Application for Removal or Variation of a Condition following Grant of Planning Permission or Listed Building Consent

Demolition and replacement of the existing detached house with a new detached dwelling (including basement) together with the retention of the existing access points and crossovers and all associated ancillary works.

11393/APP/2021/3940

The approved drawings nos. 1382/P/1C, 2A, 3A & 5A

drawing: PLANNING PROPOSALS,
SITE LAYOUT PLAN & LOCATION PLAN

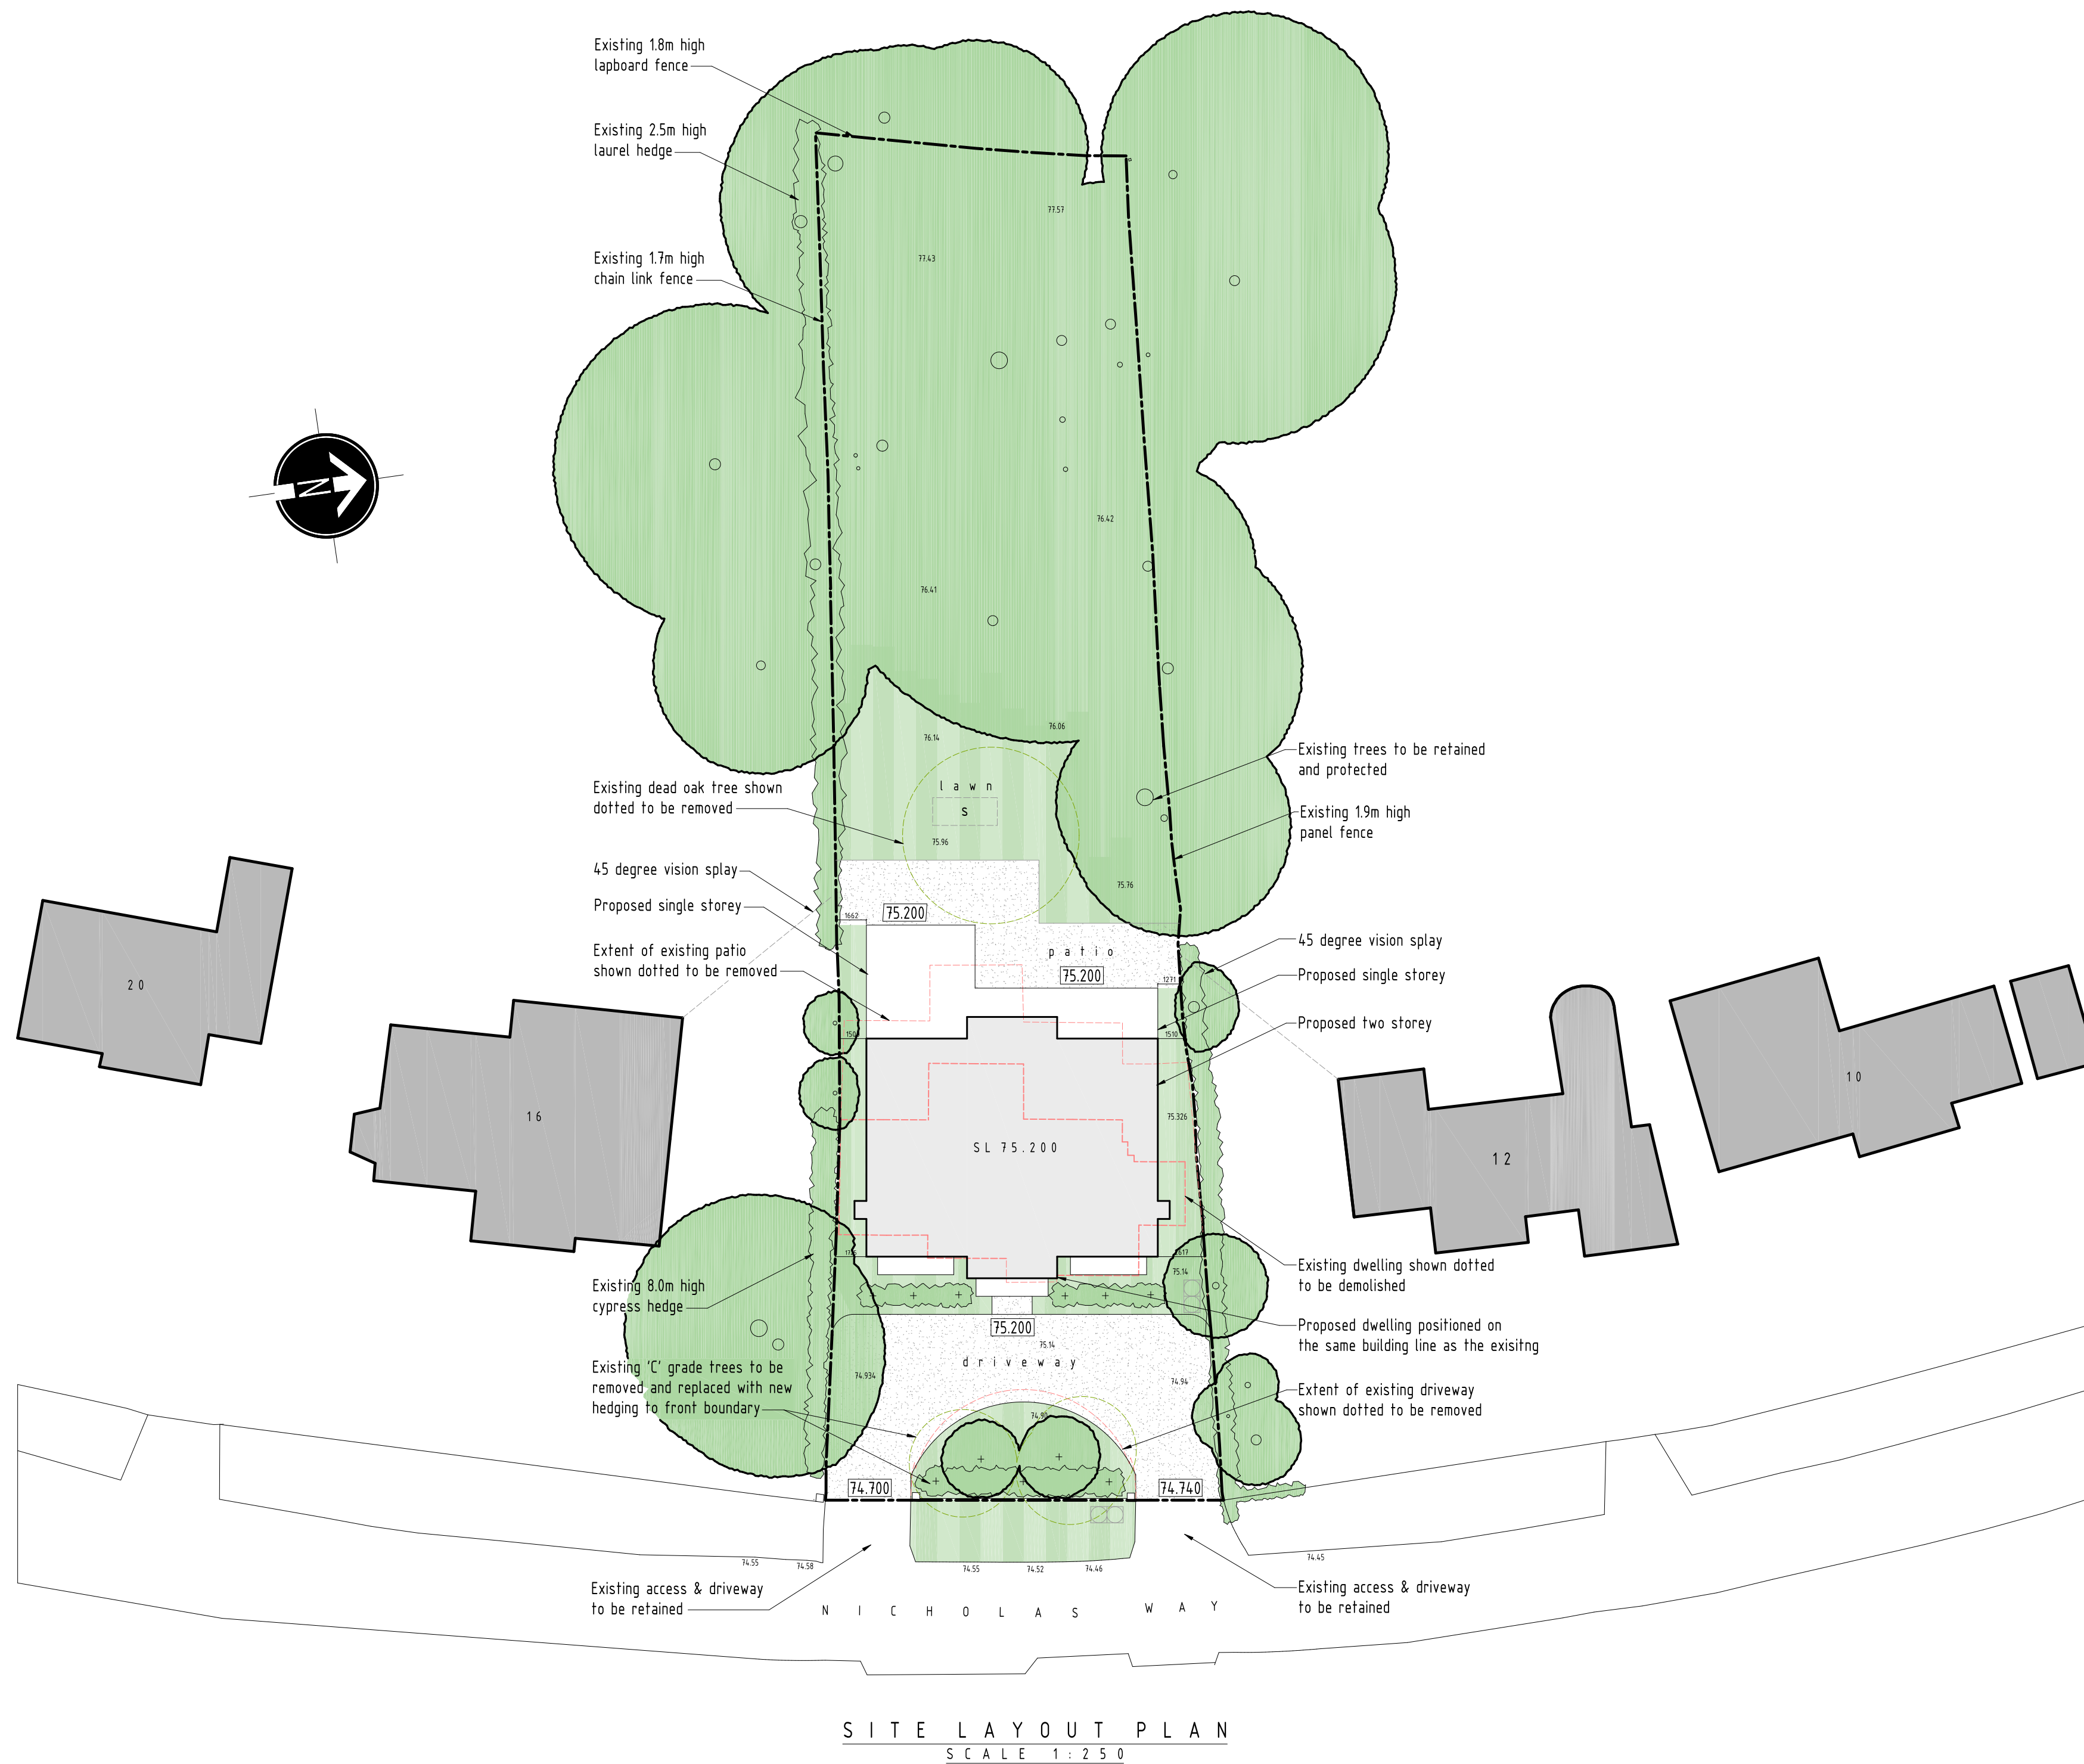
- Render removed from front and rear elevations, and replaced with brick
- Brick quoins added to front elevation and to match main brick
- Family and kitchen area handed, with 2x external windows moved to opposite side elevation
- Formal lounge side elevation windows removed
- Utility room handed to opposite side elevation and door added
- Parent bedroom en-suite re-located and side window added
- Bedrooms 2 and 3 handed, with flank windows swapping to opposite side elevation

Drawing nos. 1382/P/1D, 2B, 3B & 5B
